From: [REDACTED]
To: [A585 Windy Harbour to Skippool](#)
Subject: Comment on Highways England Recent Documents.
Date: 08 June 2019 21:23:54
Attachments: [Comment on documents from Highways England.docx](#)

**Re. Application Document Ref: TR010035/APP/ 7.10 – Rev 0
Responses to the Examining Authority's Written Questions**

**Re Application Document Ref: TR010035/APP/8.2
Statement of Common Ground with Lancashire County Council**

Re. Application Document Ref: TR010035/APP/ 7.19 – Rev 0
Comments on Local Impact Reports

Appendix A: Proposed Highways England improvements alongside Scheme

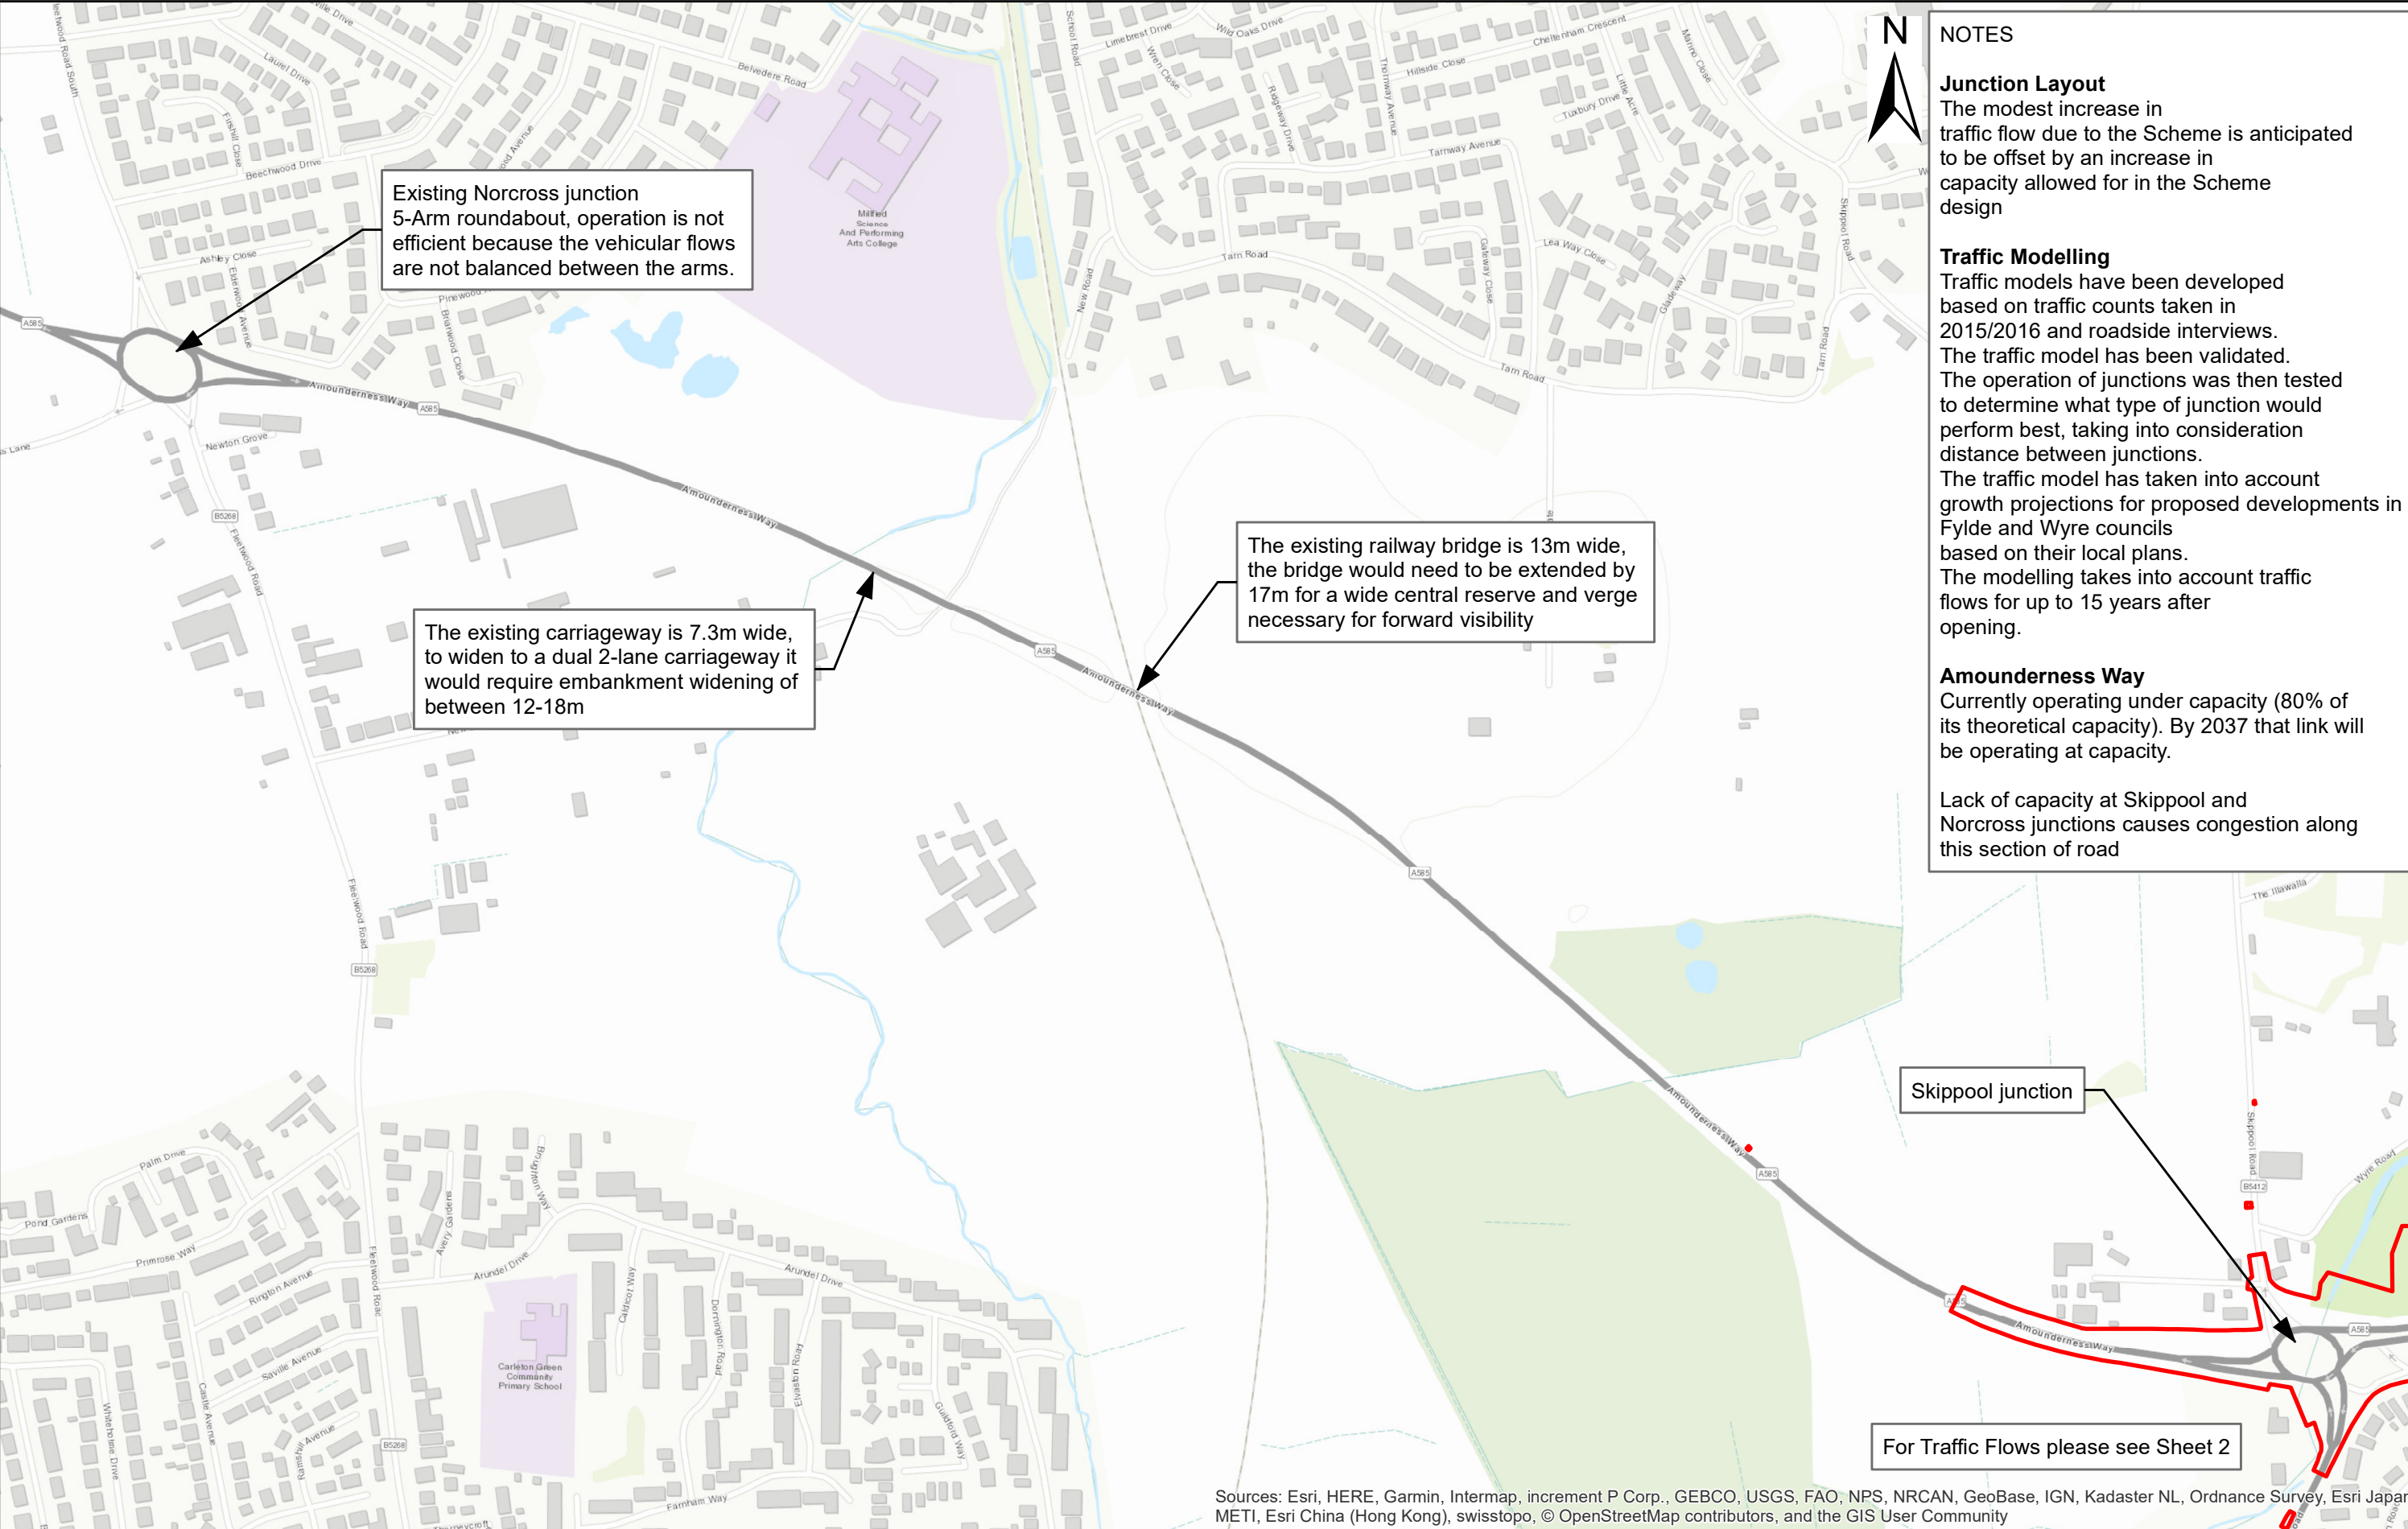
In their response (at page 45) Highways England referred to the junction improvements and the Cycle Routes: A585 – Fleetwood to West Drive; A585 – West Drive to Thornton Roundabout (Morrisons); A585 – Thornton to Skippool.

These routes are intended to form a continuous route from Fleetwood to Skippool junction for cyclists and pedestrians as a shared path on the east side of the A585. This is not only to provide a safe and convenient route for cyclists and pedestrians but also to aid motor traffic flow by reducing the delays caused by the difficulty of safely overtaking cyclists who currently ride on the carriageway. To encourage cyclists to use these shared paths rather than the carriageway it is important that they are of high and consistent quality beside the A585 and with convenient crossings of side roads and major junctions so they are not significantly slower than using the carriageway. Without this cyclists will use the main carriageway as many do now. It is for this reason that it is important that this new section of the A585 should have a cycle and pedestrian facility along the east side all the way from Skippool to Windy Harbour Junction. If cyclists are directed to deviate away from the main road via Mains Lane and the closed off old road (which will soon become a mess when used for agricultural access) most cyclists will ride on the carriageway as is their legal right.

Future schemes will need to provide a continuation of the shared path on the east side of the A585 south from Windy Harbour to Thistleton, Esprick and the M55 J3. Cyclists can then continue to Kirkham on the LCC managed section of the A585.
